**From:** [REDACTED]  
**To:** [Manston Airport](mailto:ManstonAirport@planninginspectorate.gov.uk)  
**Subject:** Re: clarification about the dispersion  
**Date:** 11 March 2019 11:57:17  
**Attachments:** [image001.png](#)  
[image001.png](#)

**From:** [REDACTED]  
**Sent:** 11 December 2018 16:46  
**To:** Manston Airport  
**Cc:** [manston@communityrelations.co.uk](mailto:manston@communityrelations.co.uk); [manstonconsultation@bdb-law.co.uk](mailto:manstonconsultation@bdb-law.co.uk)  
**Subject:** clarification about the dispersion

Figure 6.19
Annual mean PM_{2.5} process contribution (excluding roads), Year 20, (wider area)

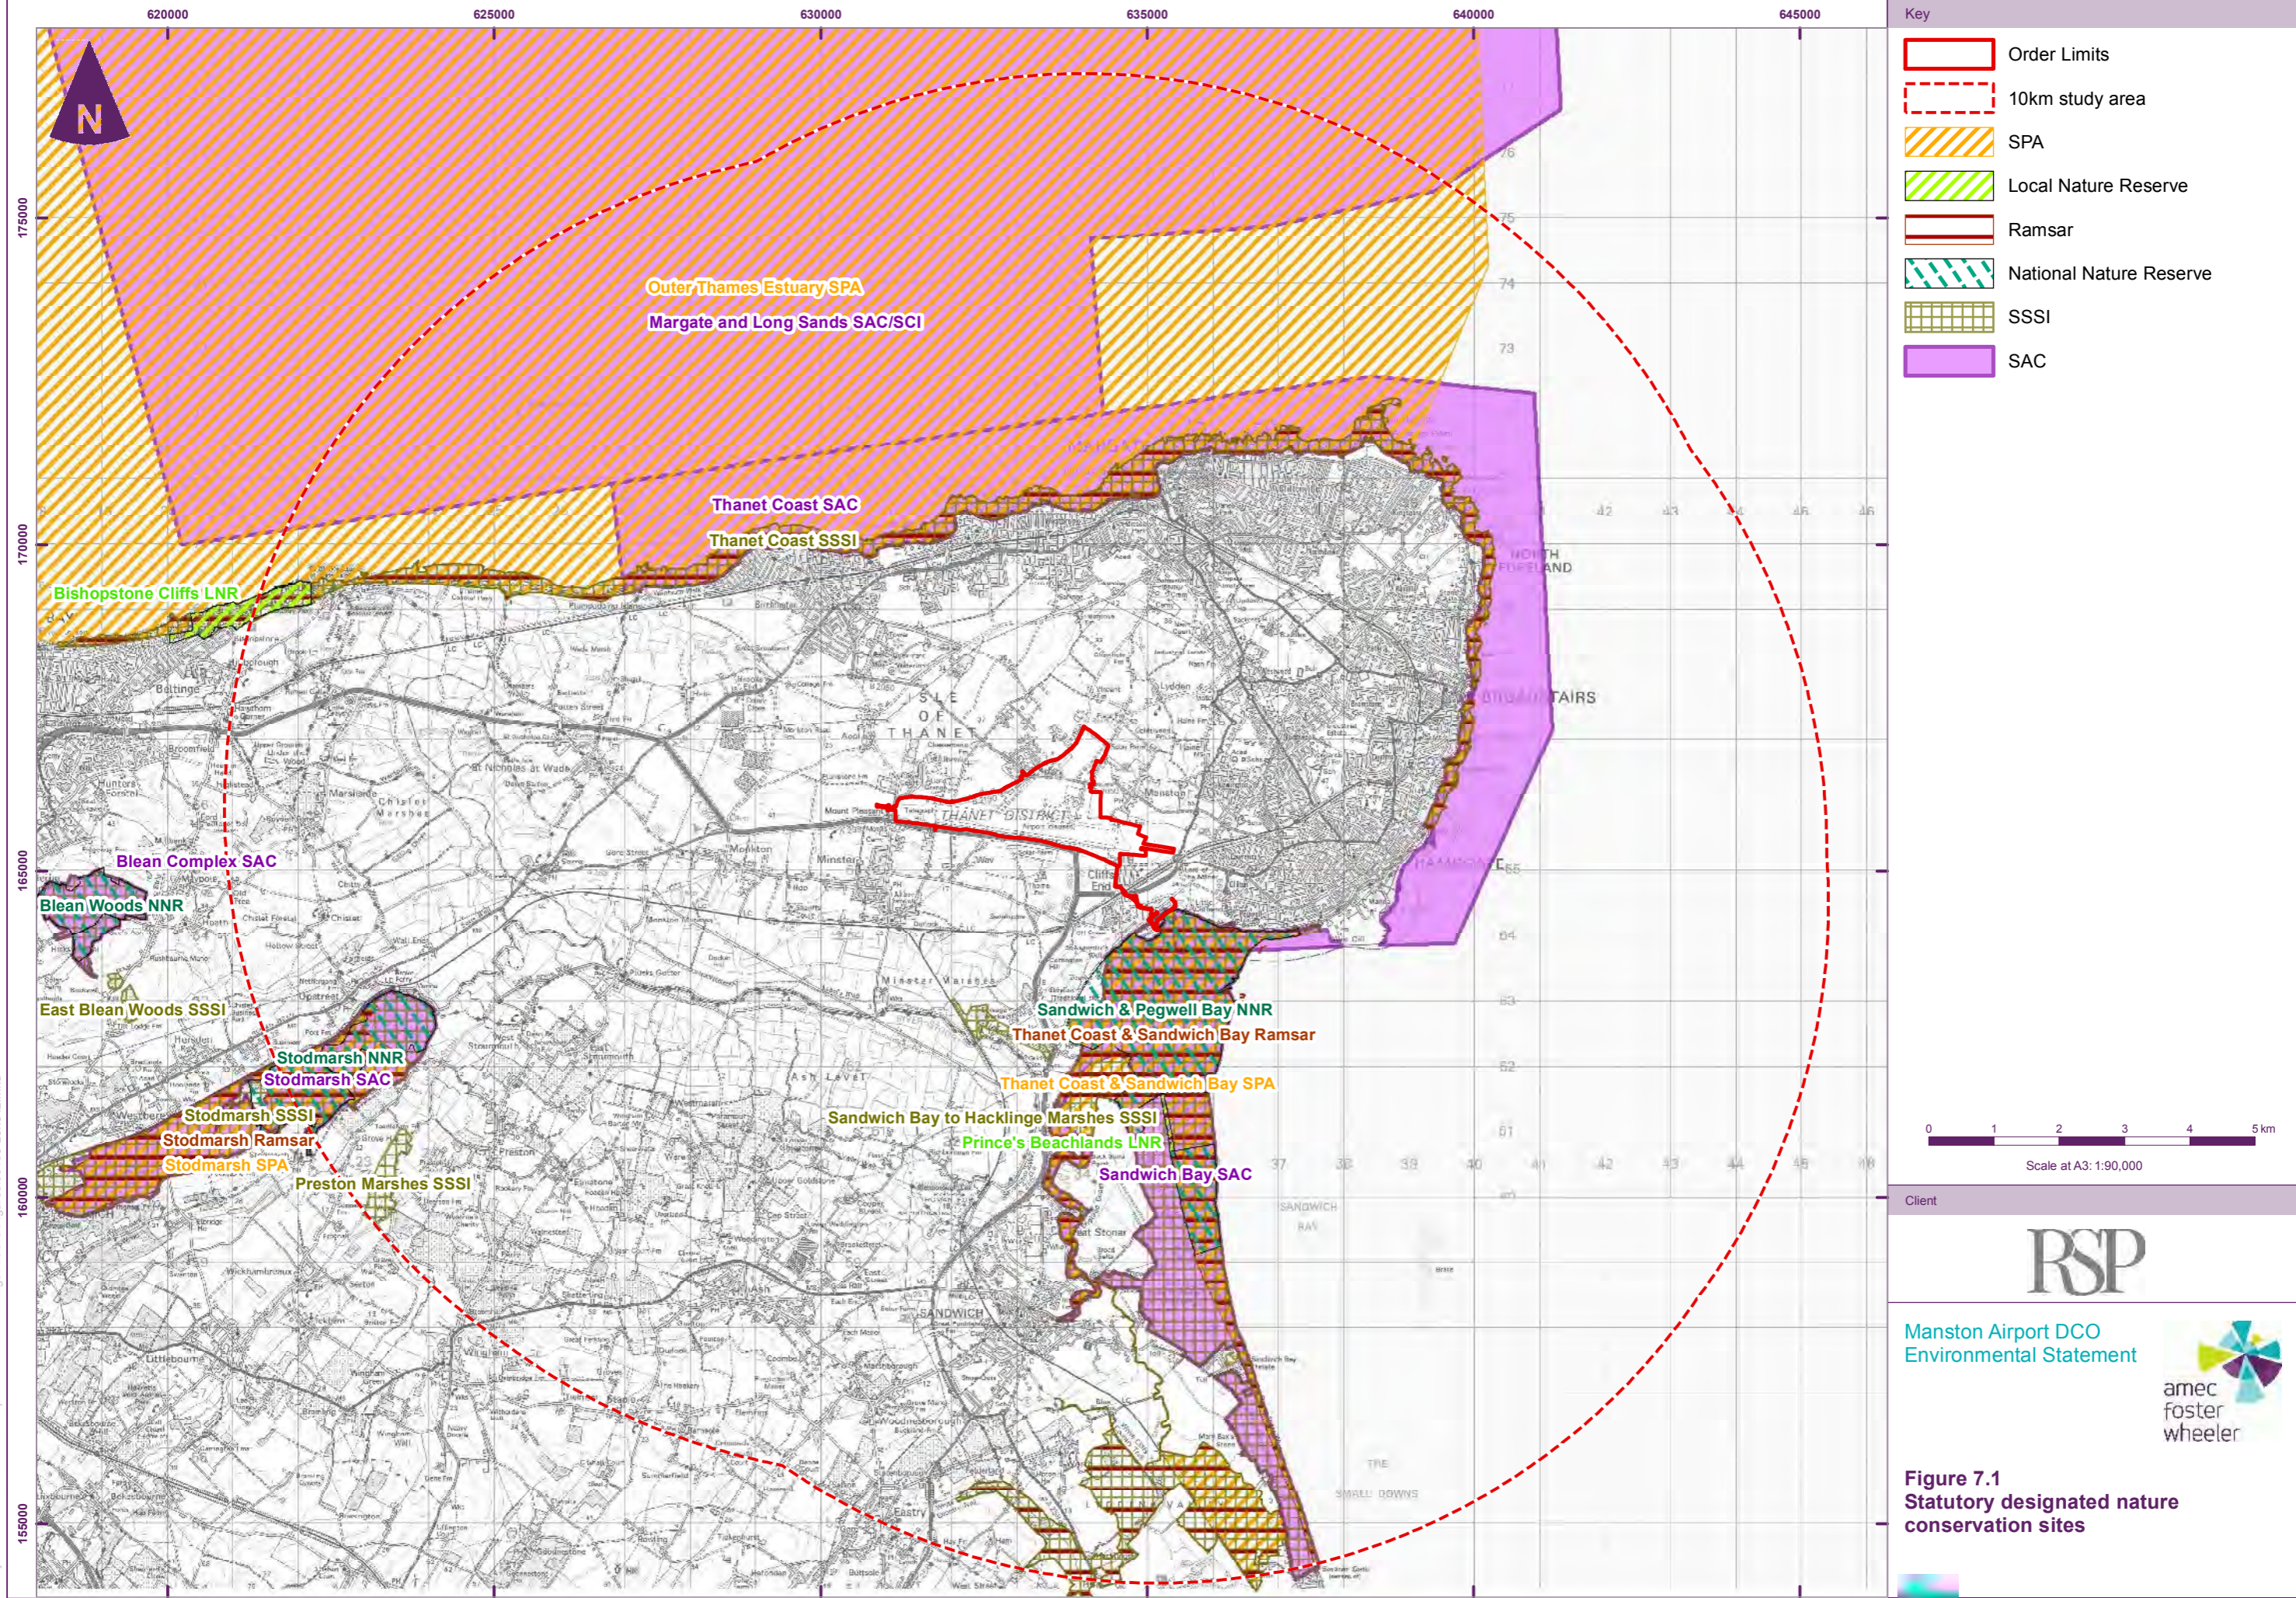
To be absolutely clear with this pm10s disperse (fall to the ground) within about 1km of the burn that generated them and pm2.5s travel much further as airborne matter and certainly further than the Thanet coastline.

RiverOaks various environmental documents all appear to have made the fundamental error of using the same dispersion distance for pm 2.5s they used for the much larger pm10s i.e. about 1km and basically not much further than the proposed airport perimeter.

In their environmental assessment results RSP either have PM2.5s travelling the same distance as PM10s or in one case actually travelling a shorter distance. They have confirmed that there are not other parts of their application where this anomaly is resolved with the links in their last email to me.

The various figures you quote for PM2.5s seem to take the dispersion distance from the fuel burn to be about 1 km max i.e. the distance for PM10s.

If the first: we have not used a simple concentration/distance relationship to calculate concentrations. Instead, we use a software tool called ADMS, which calculates the transport and dispersion of pollution taking into account different wind speeds and directions as well as different amounts of turbulent mixing in the atmosphere from hour to hour. It uses five years of historical weather data, measured at the Manston Met Office station. This provides a high degree of accuracy in our forecast results.

If the second: Presenting concentrations as a line graph as a function of distance from the source is sometimes done for certain types of assessment, such as accidental releases of hazardous material to air from a point source. However, presenting results like this does not account for the difference in wind direction over the course of a year. For an accidental release, which is of short duration, it is common to make the worst-case assumption that the wind is blowing towards the sensitive receptors for the whole duration of the release. For sources where emissions occur throughout the year, such as at Manston Airport, this is not a sensible assumption.

In addition, the emissions from Manston Airport will come from several moving sources spread over several square kilometres, so the concept of “distance from the source” does not work well in this case.

Therefore, the usual graphical way of presenting the effects of dispersion is as contour plots of concentration. The concentration in ug/m<sup>3</sup> at a given location (e.g. a residential property) can be read off the contour plot and compared against the legal limits or health guidance recommendations. Suitable contour plots for PM<sub>10</sub> and PM<sub>2.5</sub> are given in the Environmental Statement (ES) as Figures 6.16 to 6.19 (which can be found here: <https://infrastructure.planninginspectorate.gov.uk/wp-content/uploads/projects/TR020002/TR020002-002414-5.2-4%20-%20Environmental%20Statement%20-%20Figures%20-%205%20of%207%20-%20Figures%204.1-9.6.pdf>). These are in addition to the tables of concentrations at specific locations, chosen to include places where people are most likely to be exposed, also included in the ES – see Sections 6.8 to 6.10 of the ES for those locations where the impact is greatest, and Appendix 6.5 for the full set of modelled locations. (Section
